Acceptance of Applications Checklist

Oaklands Farm Solar Park Section 55 Acceptance of Applications Checklist

Section 55(2) Acceptance of Applications				
1	Within 28 days (starting day after receipt) the Planning Inspectorate must decide whether or not to accept the application for Examination.	Date received	28 day due date	Date of decision
		8 February 2024	7 March 2024	5 March 2024
Section 55(3) – the Planning Inspectorate may only accept an application if it concludes that:		Planning Inspectorate comments		
Section 55(3)(a) and s55(3)(c): It is an application for an order granting development consent				
2	Is the development a Nationally Significant Infrastructure Project ¹ (NSIP) (or does it form part of an NSIP); and does the application state on the face of it that it is an application for a Development Consent Order ² (DCO) under the Planning Act 2008 (the PA2008), or equivalent words? Does the application specify the development to which it relates (i.e. which category or categories in ss14 to 30 does the Proposed Development fall)?	<p>Yes</p> <p>The Proposed Development set out in Schedule 1 of the Draft DCO (Doc 3.1) includes development falling within the categories i

Drawing Title
**Works Plan
 Sheet 3**

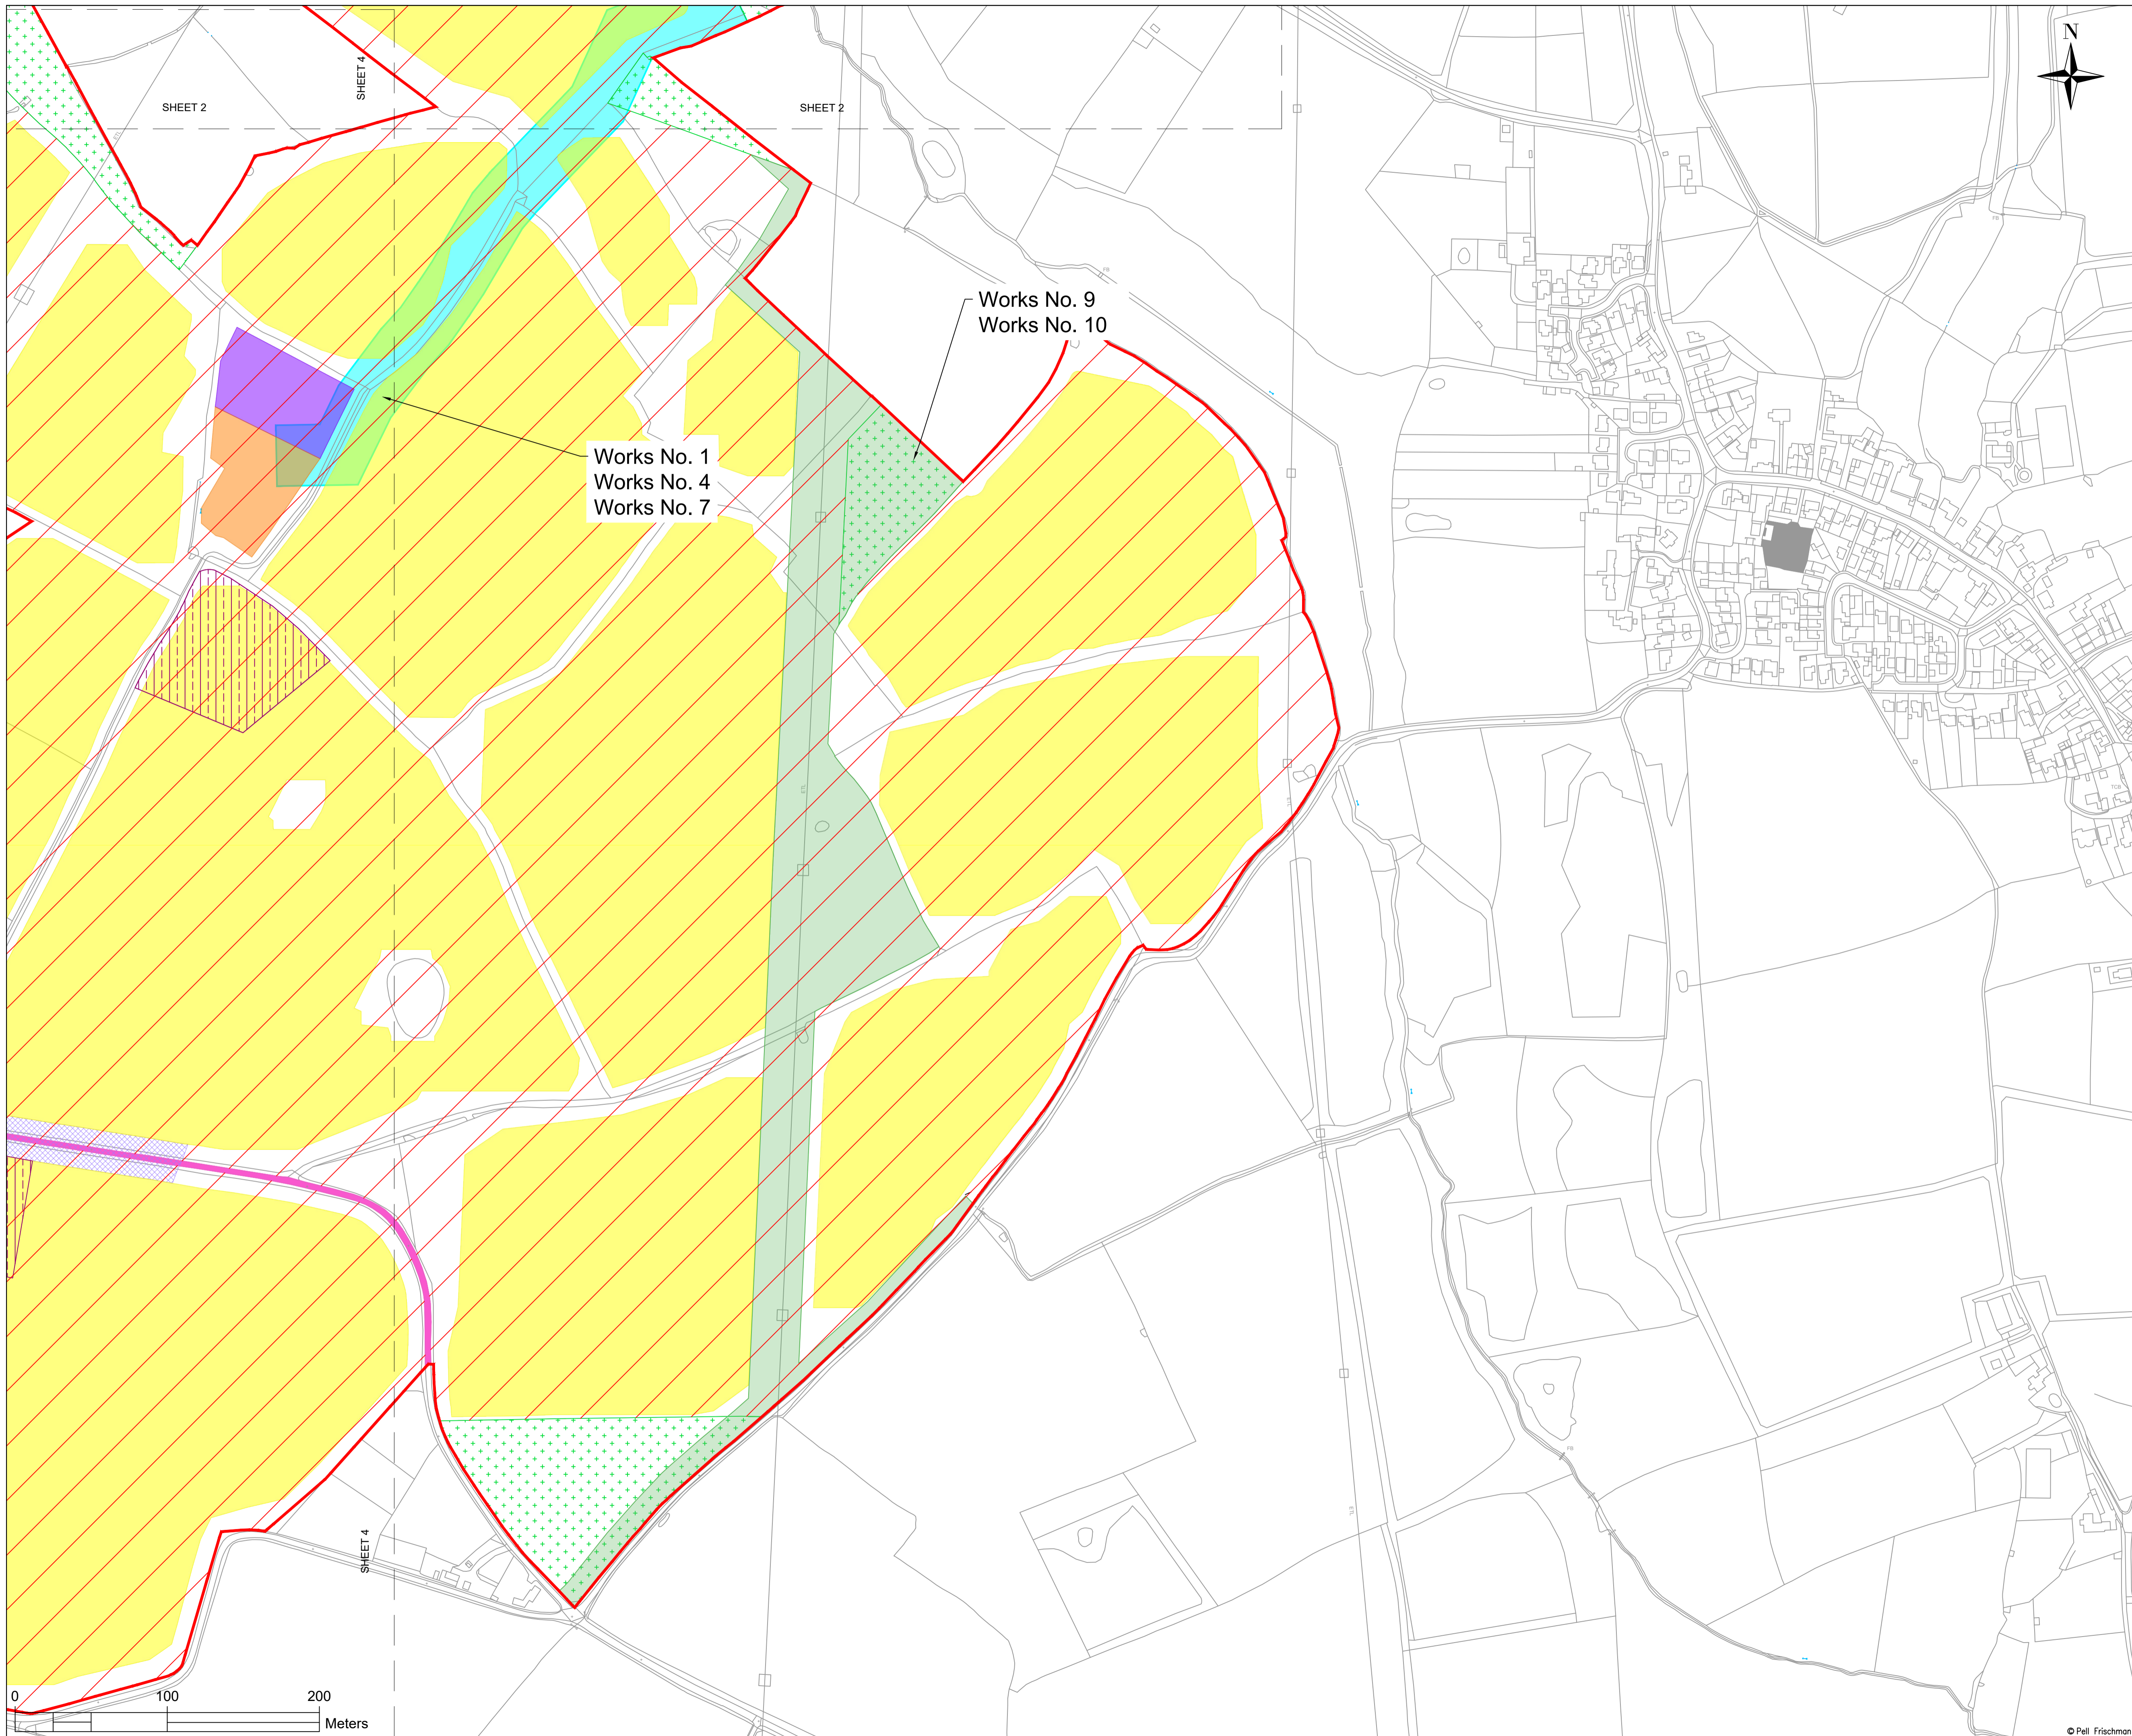
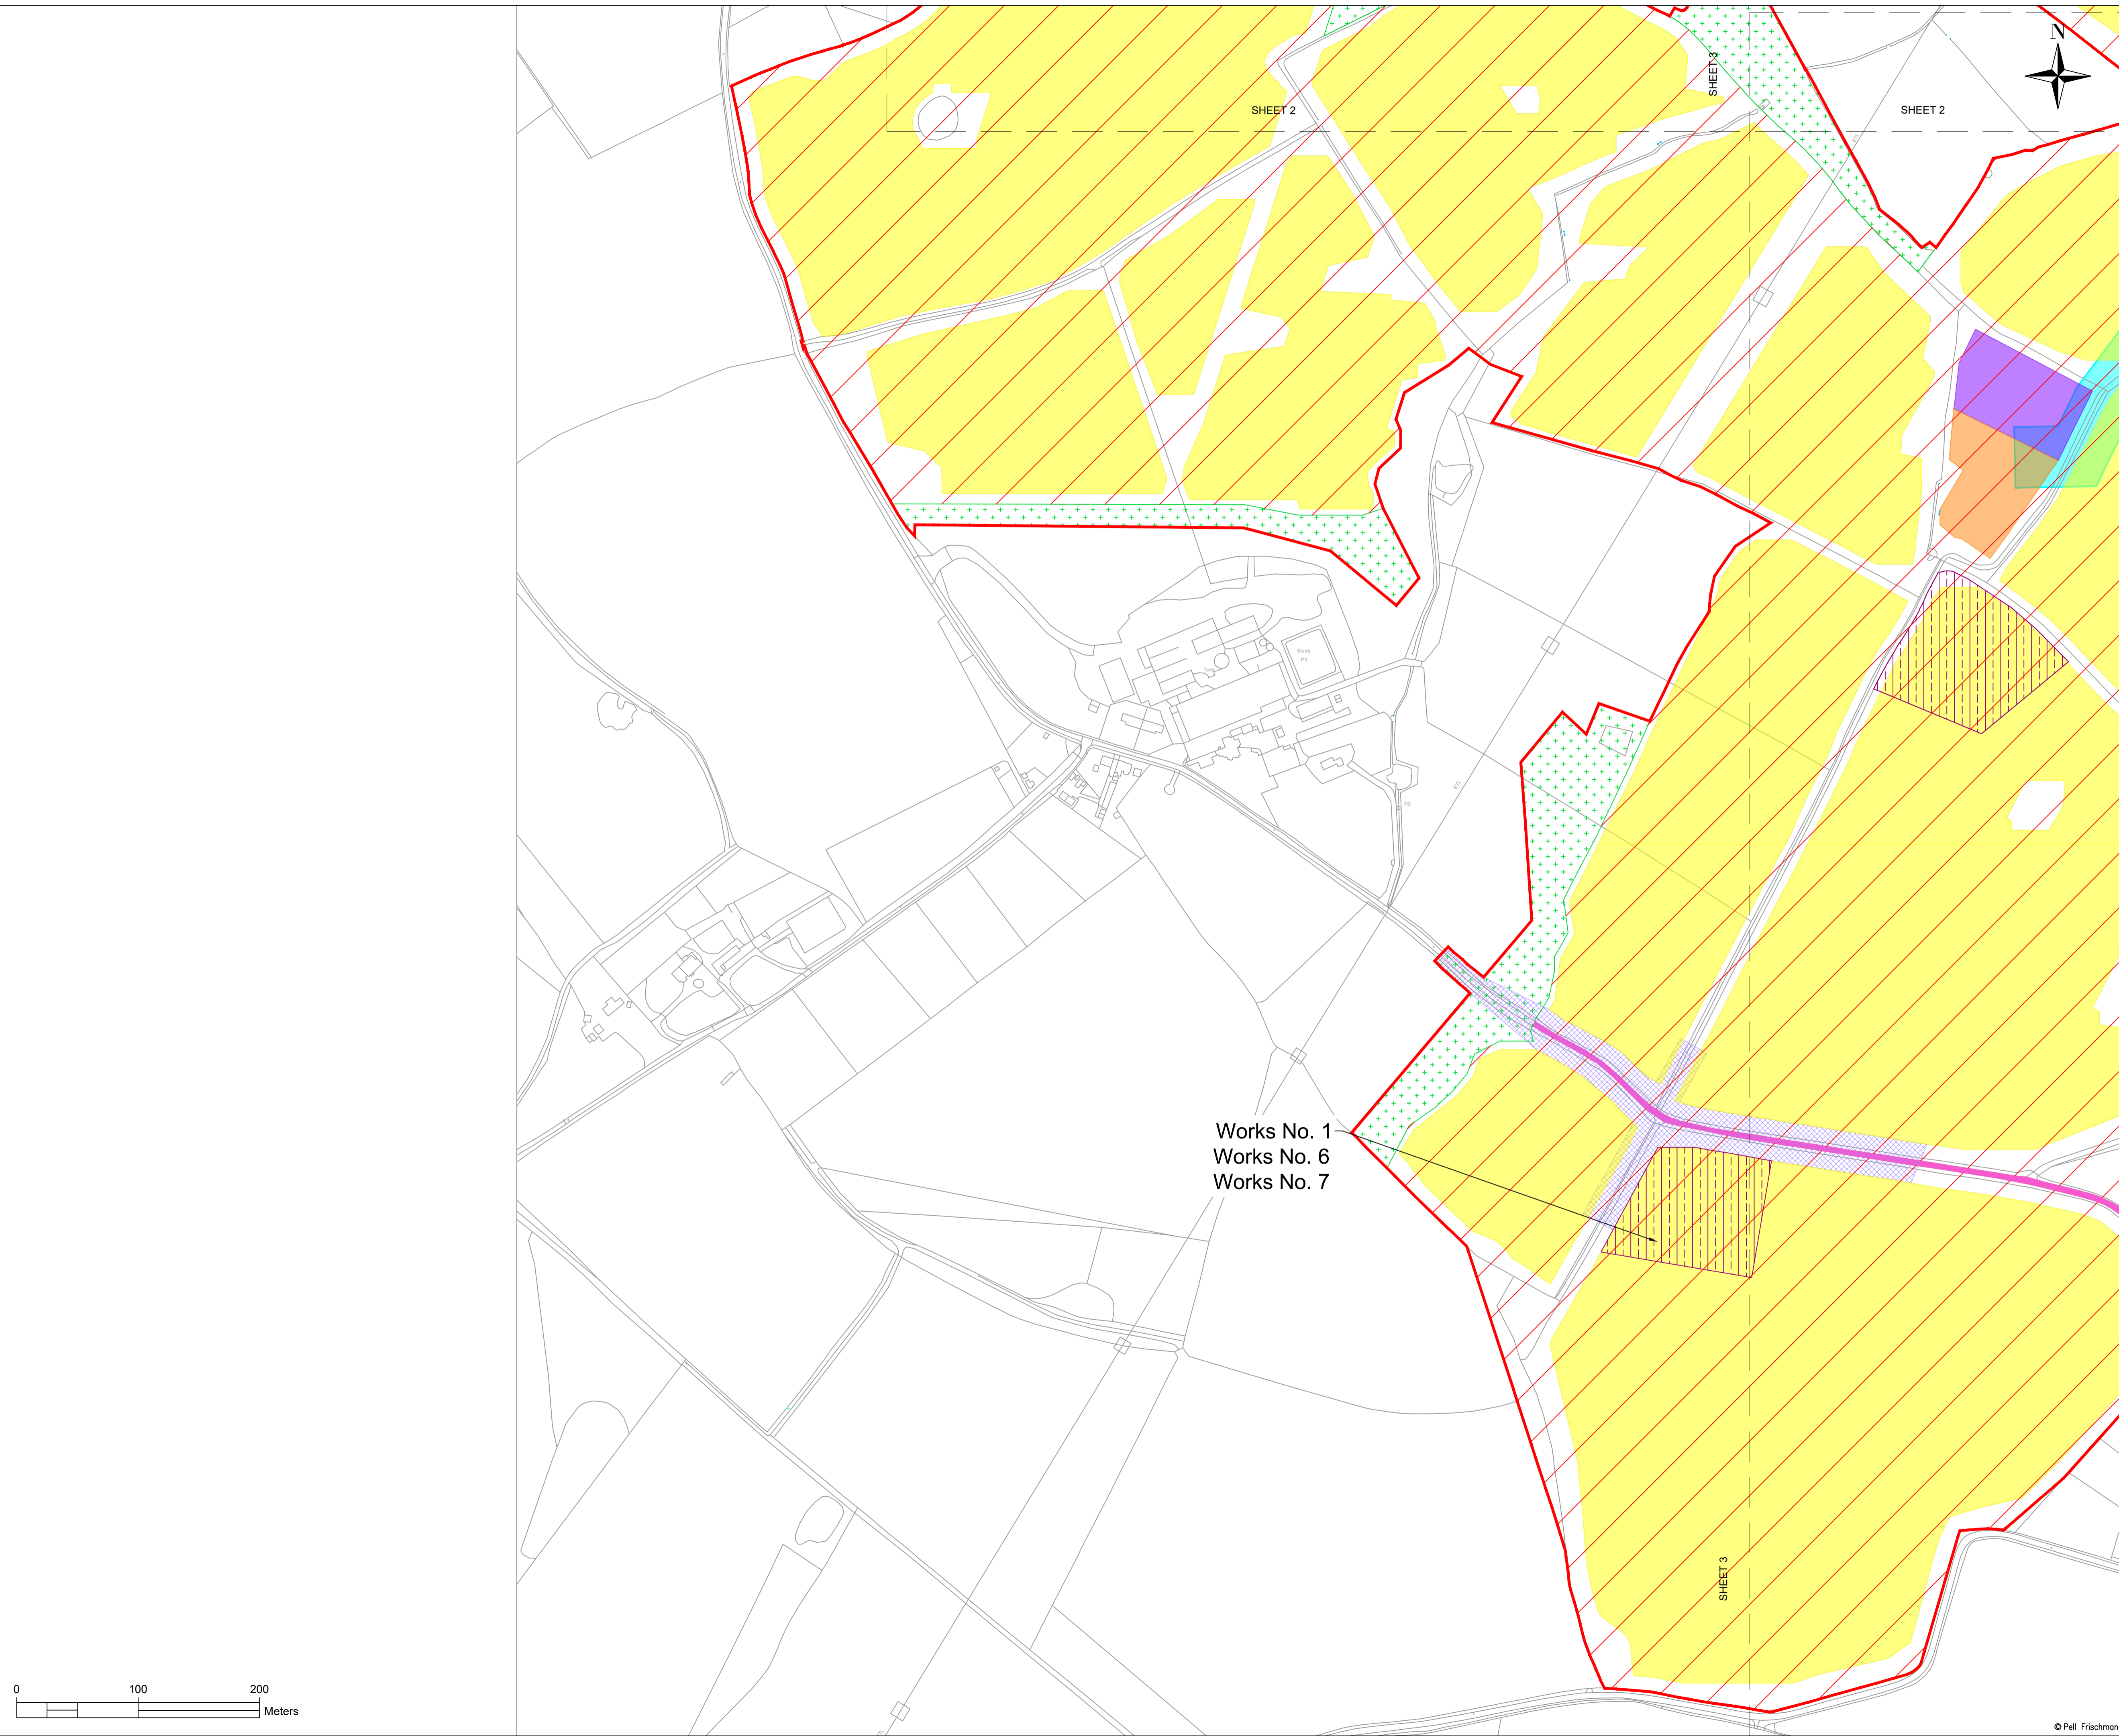
Works no. 2, 3, 4d, 6 and 8 are not labelled on Sheets 3 and 4.
